From: Gemma Magnuson
Sent: 29 July 2020 12:41
To: DC Support
Subject: FW: Planning notification for application reference: 20/01832/F

From: Jonathan Emanuel <jonathan.emanuel@cherwell-dc.gov.uk>
Sent: 29 July 2020 12:11
To: Gemma Magnuson <Gemma.Magnuson@cherwell-dc.gov.uk>
Subject: RE: Planning notification for application reference: 20/01832/F

Proposed Block Plan
Scale. 1:500

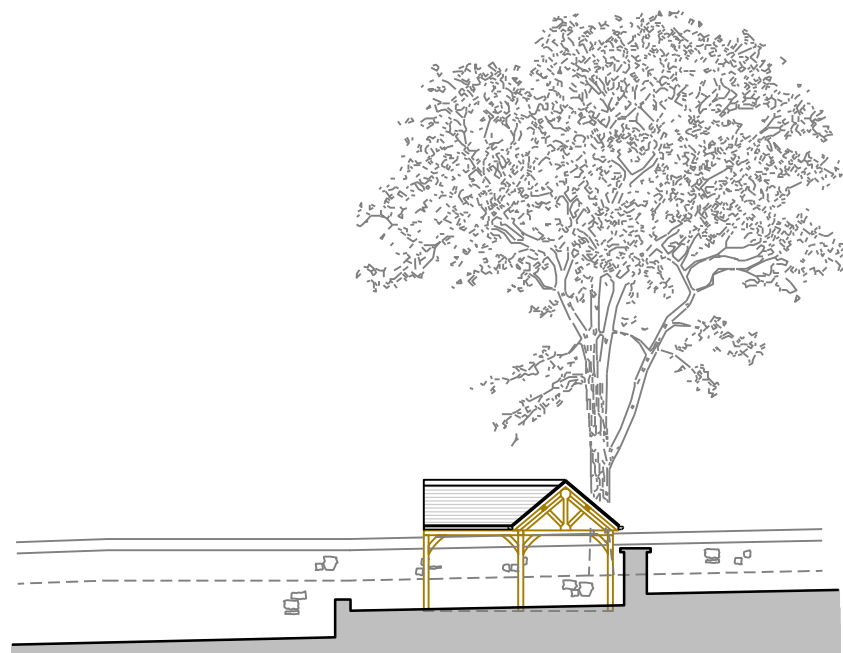
Having assessed the application on the information submitted, my concerns would be as to any excavation works for the proposed reclaimed red brick floor laid in a herringbone pattern.

It appears that trees are within the proximity of the proposal this may have an impact on the trees, I would therefore ask to have a BS5837 Arboricultural Impact Assessment report.
